DRB Application No.: 03-00566 (SBP)  
Project Name: North Albuquerque Acres  
Agent: Advanced Engineering & Consulting

DRB Application No.: 06DRB-01370 (ASBP)  
Project Name NO ALBUQ. ACRES, TRACT A  
Agent: David Green

**CITY OF ALBUQUERQUE  
 PLANNING DEPARTMENT  
 DEVELOPMENT REVIEW BOARD  
 4/16/03 Comments**

**Subject: North Albuquerque Acres, Lot 29, Block 5, Tract A, Unit B**

DRAWING:	DRAWN BY:	DATE:	SHEET #
200121-LS.DWG	CMD	01-28-03	2 OF 4

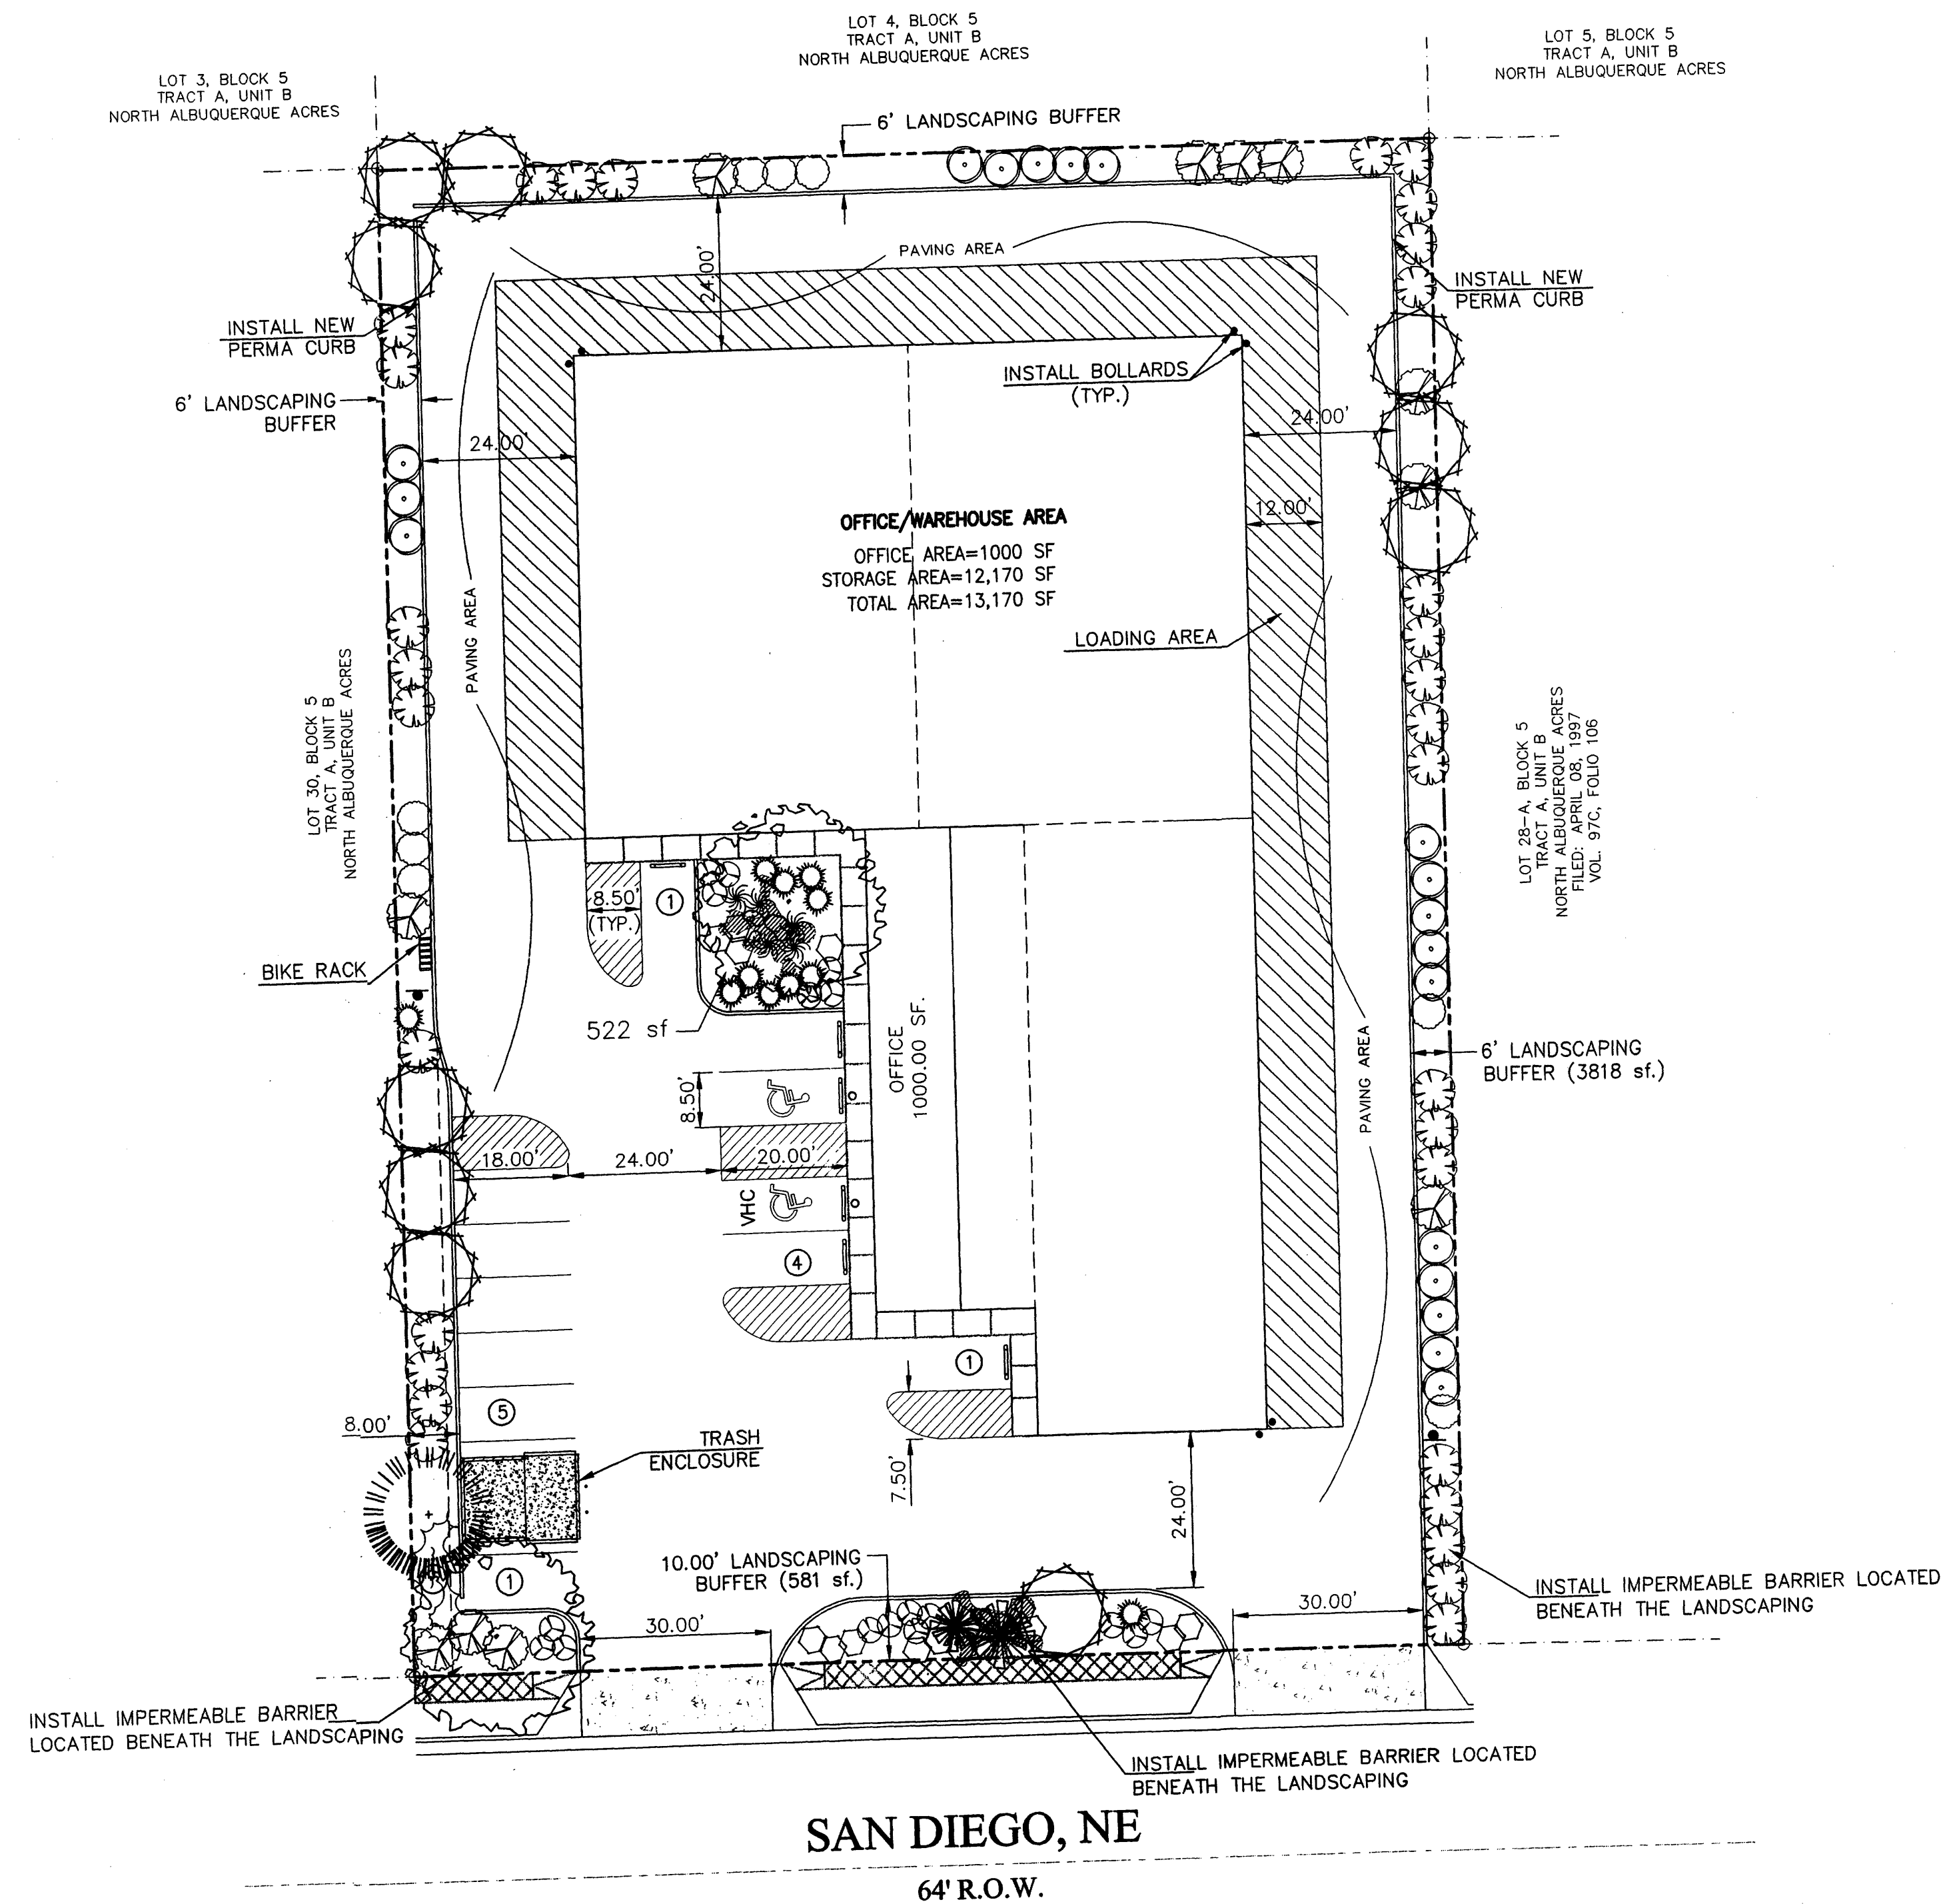
The west side landscaping buffer should incorporate more trees to conform with the North I-25 Sector Plan requirement: "Plantings should be placed on the site to provide shade for pedestrian and buildings during the summer months." More trees are needed in the back half of the buffer on the west side.

In addition, the honey locust, ash & Austrian pine are high water use trees. When you increase the number of trees on the west side, please refrain from using more high water use trees. It would be a good idea to exchange lower water use trees for the 3 high water use species now shown on the site plan. The juniper are high allergen shrubs and not native to New Mexico. We strongly recommend you substitute native, lower allergen species.
